Comments for Planning Application 21/00264/CEU

Address: Madina Mosque 2 Stanley Road Oxford OX4 1QZ

Proposal: Application to certify that the existing single storey outbuilding is lawful development.

EXISTING ELEVATION

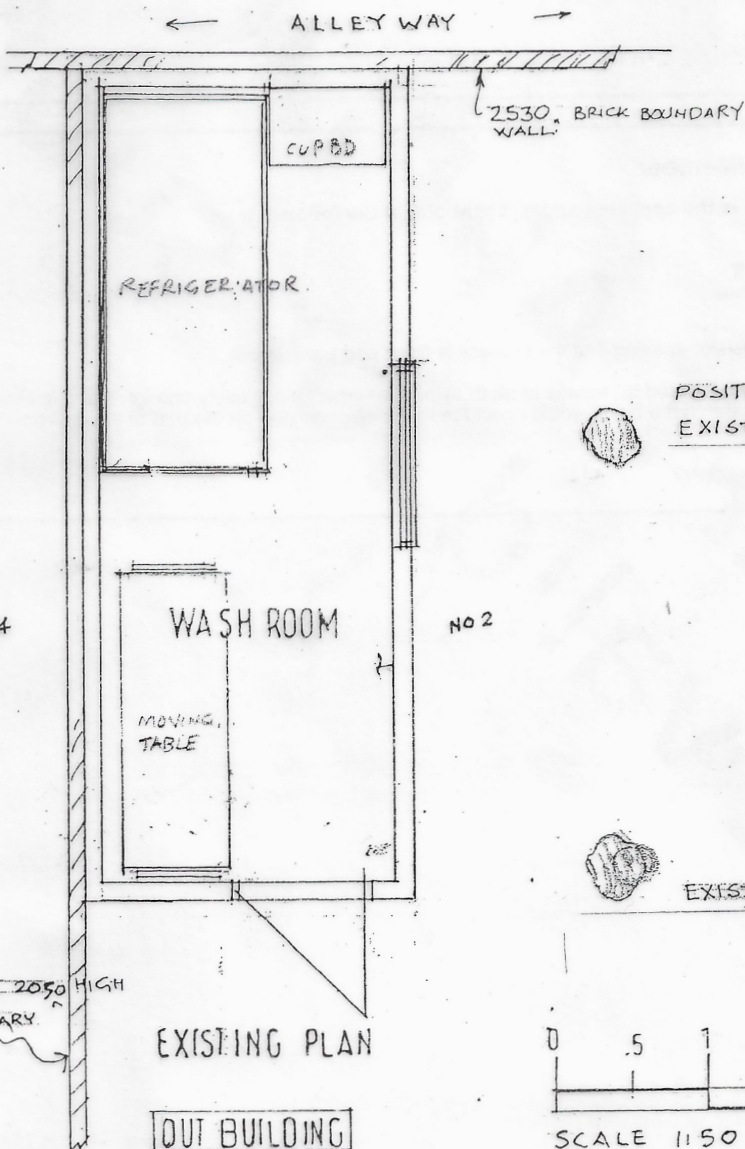
SK7 Existing Elevation: fails to show that the mortuary roof extends over and rests on the no. 4 boundary wall. The wall height is inaccurate. The phrase 'fence (brick wall)' is misleading and inaccurate.

SK7 Existing Plan: suggests that there is a separate solid wall built within the mortuary up against No 4 and up against the rear boundary wall. Do these walls really exist?

Regularisation of use as mortuary would be conditional on rebuilding the outbuilding in accordance with OCC Planning regulations including the Party Wall Act 1996.

EXISTING SIDE ELEVATION 2 (NO CHANGED PROPOSED)
AS SEEN FROM NO 4 STANLEY ROAD -

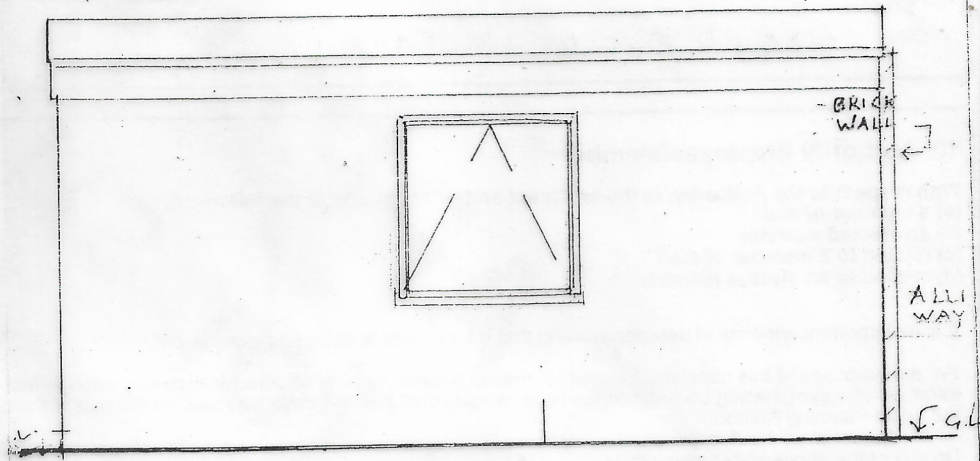
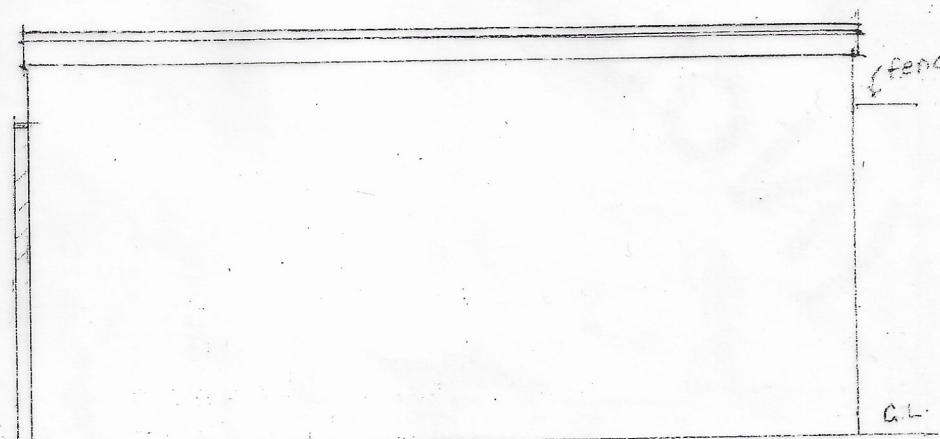
SK8: similar comments
